WEST SUSSEX COUNTY COUNCIL CONSULTATION

TO:	Arun District Council FAO: Michael Eastham
FROM:	WSCC - Highway Authority
DATE:	16 February 2022
LOCATION:	Land north of Toddington Lane (adjacent to Lyminster Bypass) Hampton Park Littlehampton BN17 7PP
SUBJECT:	LU/417/21/OUT Outline application with some matters reserved (except access) for the erection of up to 71 No dwellings.
DATE OF SITE VISIT:	n/a (desktop study)
RECOMMENDATION:	More Information Required
S106 CONTRIBUTION TOTAL:	TBA

This is the WSCC County Highways (CHA) response to the above outline planning application with some matters reserved (except access) for the erection of up to 71 dwellings.

Figure 3. Proposed Layout - Site A

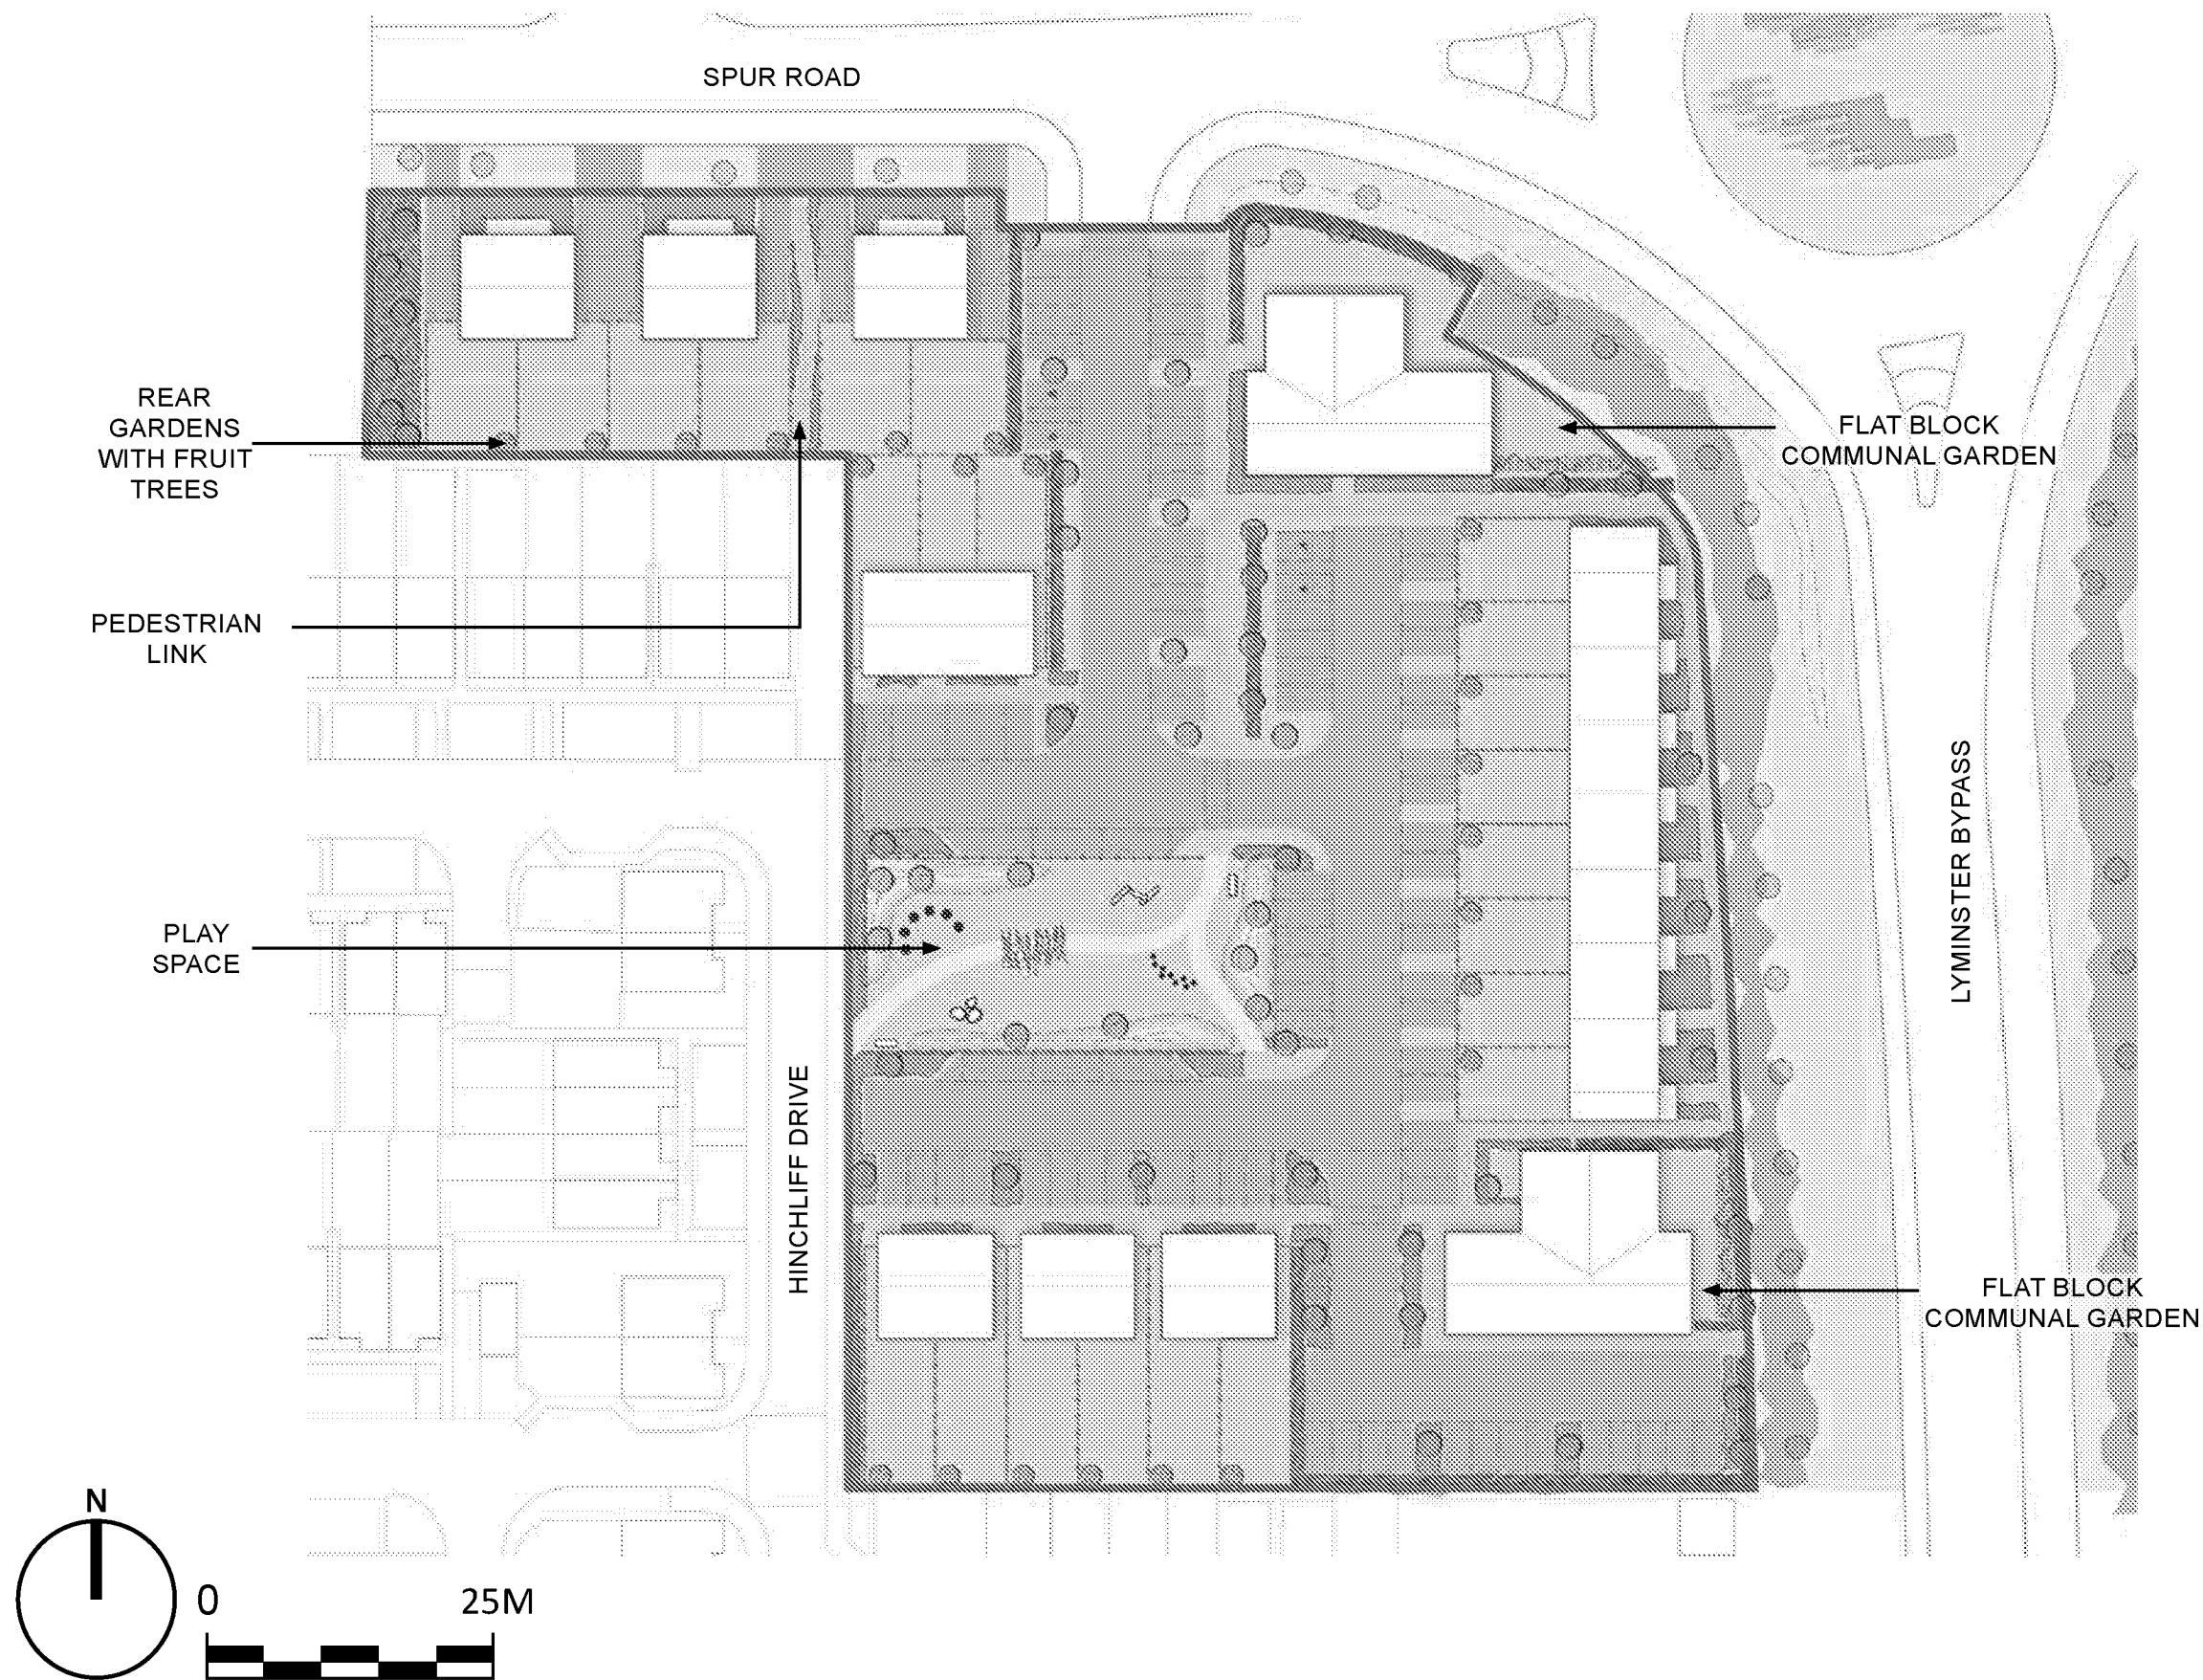
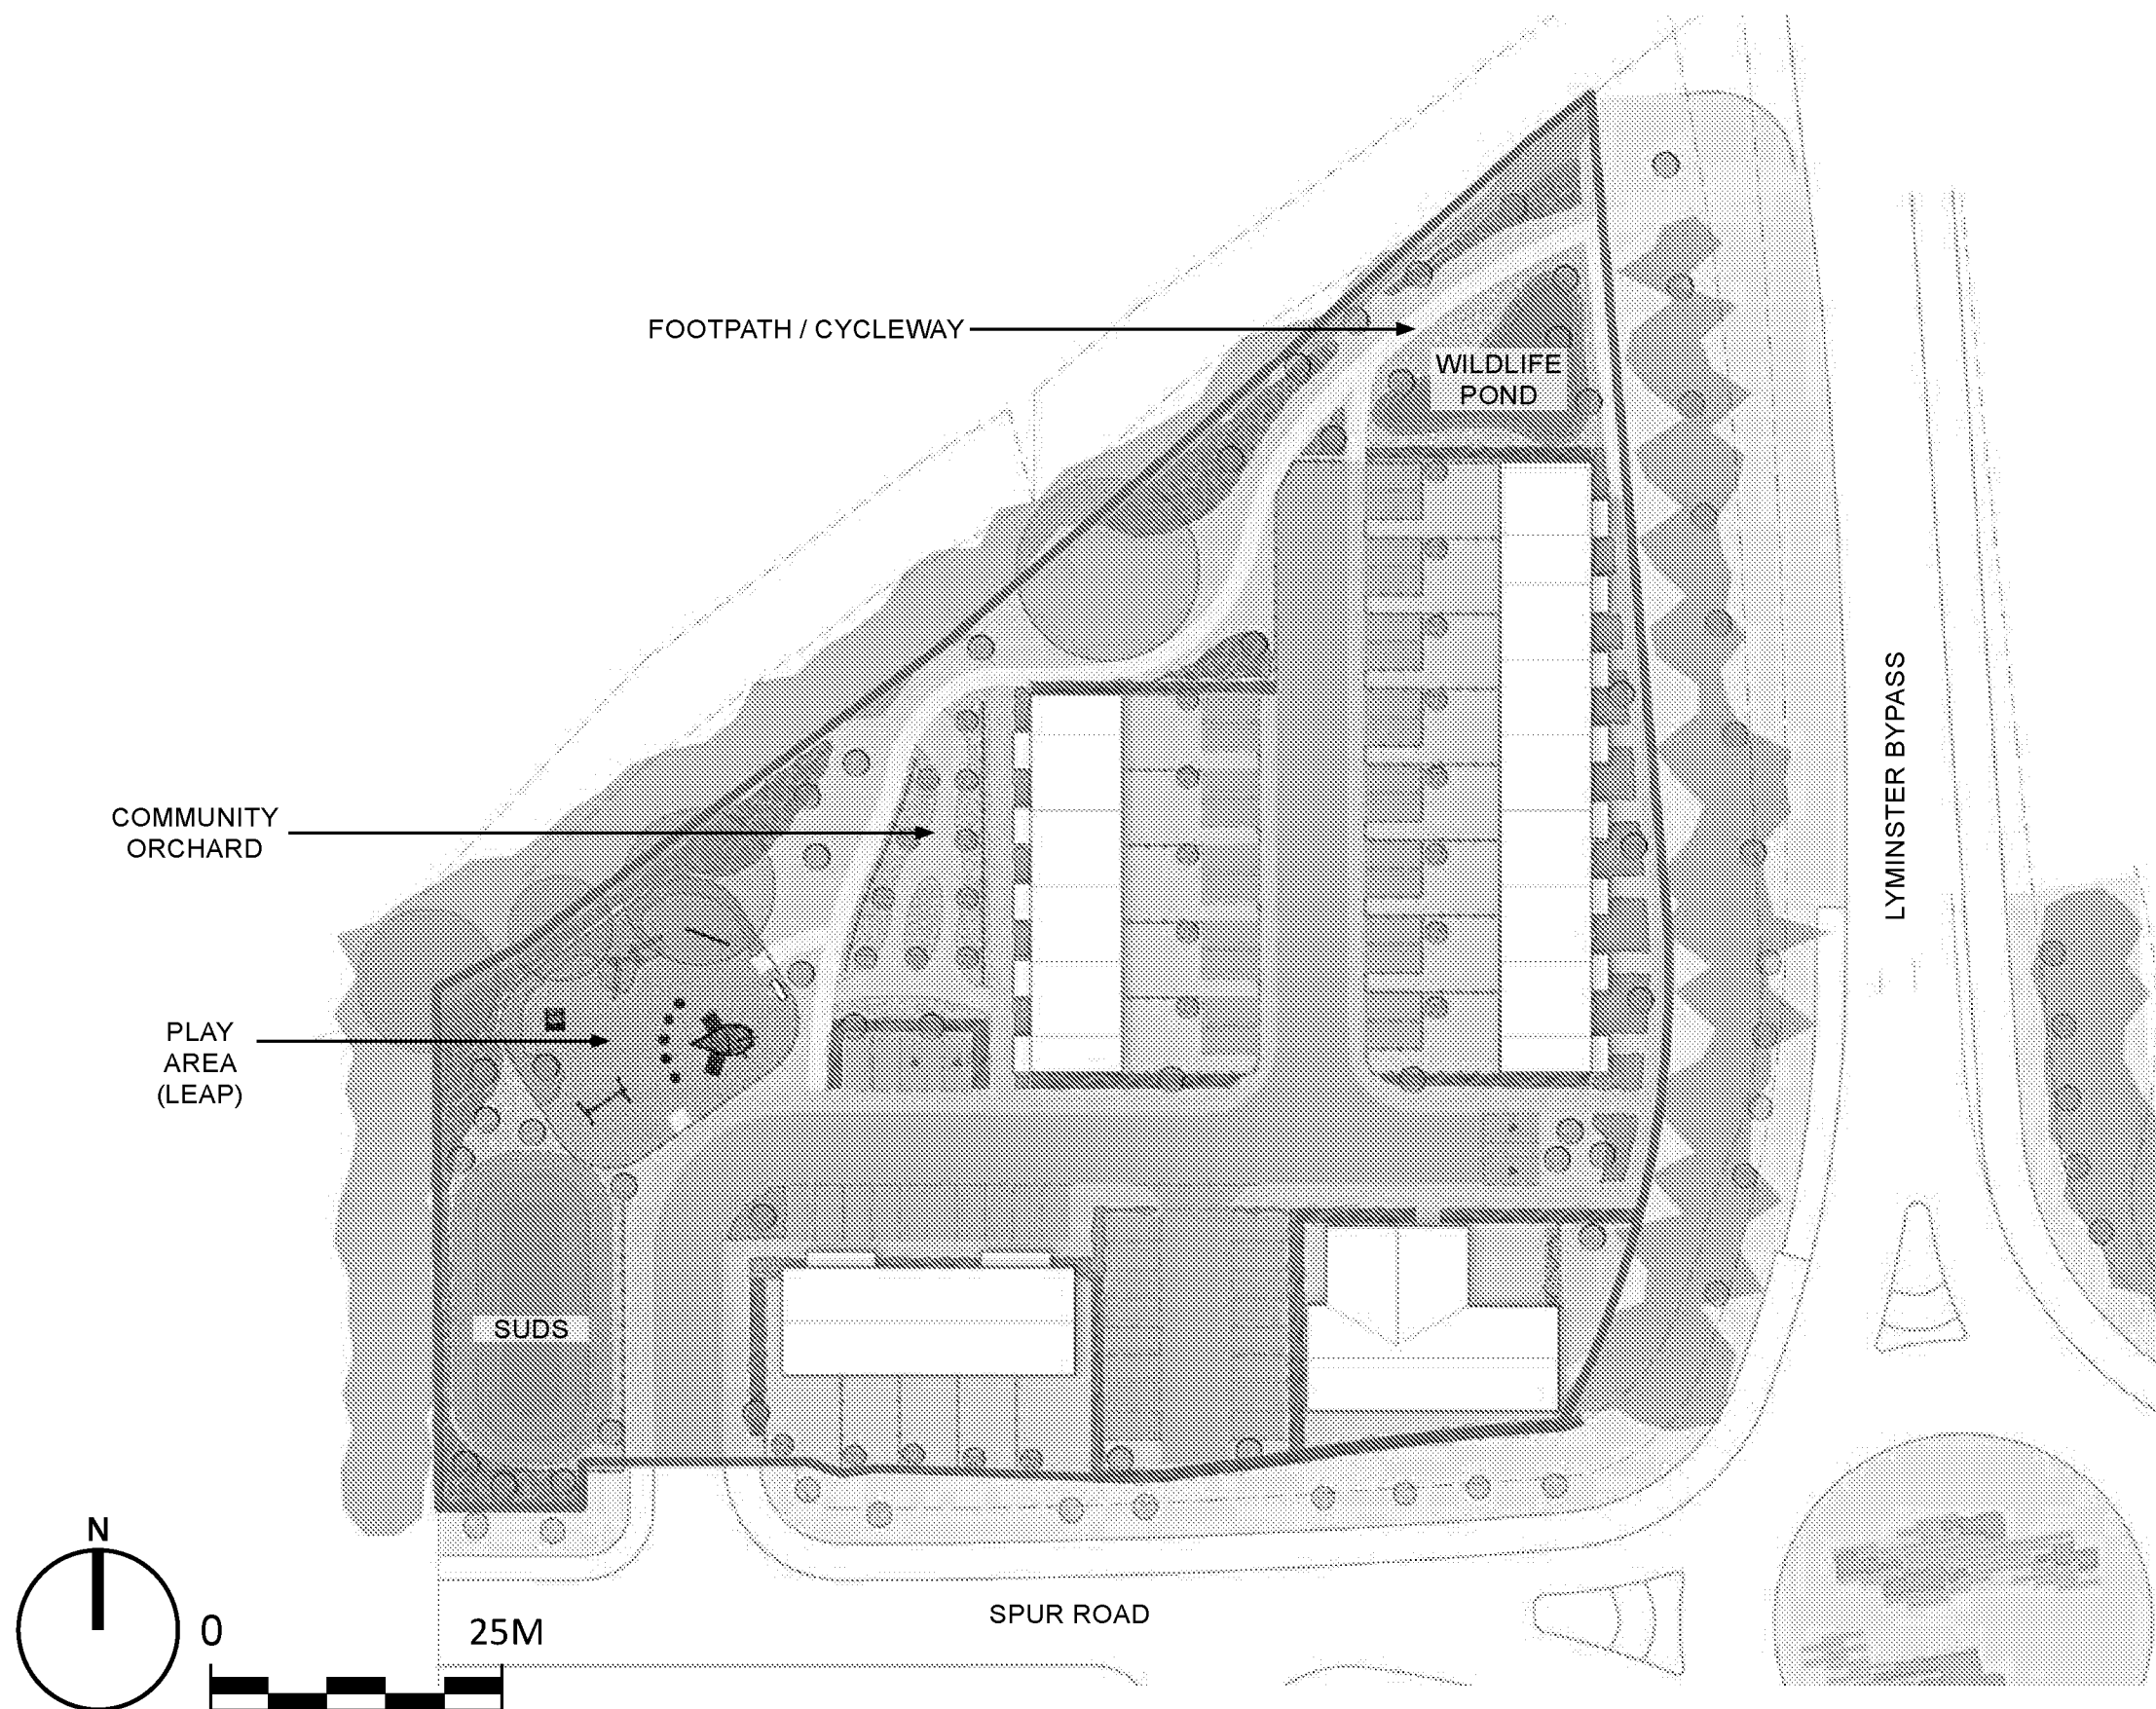
Finally, a path is shown running around the top part of the northern plot and emerging to the proposed Lyminster By-Pass. As there is no path proposed on the western side of the By-Pass for this path to connect to, the CHA ask that this be removed from the scheme as it would require users to emerge to the road at a point where no walking or cycling infrastructure is proposed. Instead, users should be directed through the development to where the infrastructure is proposed.

Car parking - Section 4 (paragraph 4.3) refers to the site providing parking in accordance with the Arun District Council adopted parking SPD. From a design point of view, all spaces should measure at least 2.4m x 4.8m. For any in garages or under-cover, these should measure 3.0m x 6.0m. For the parallel parking shown alongside the green space in the southern land parcel, a 1.0m wide section of hardstanding should be provided alongside (on the green space side) to assist occupants of the vehicles when stepping in and out of those vehicles.

Electric vehicle (EV) parking – None appears to be shown on the submitted drawings, nor is it referred to in the TA or TP. In-line with emerging guidance, from April 2022 all new homes constructed will need to be provided with EV charging points. As a number of the parking spaces are shown located away/remote and/or positioned in such a way that

Cycle parking – This is referred to in the TA but is not shown on the submitted drawings. This will need to be attended to at the detailed design stage. Additionally, visitor provision will also need to be provided in suitable locations.
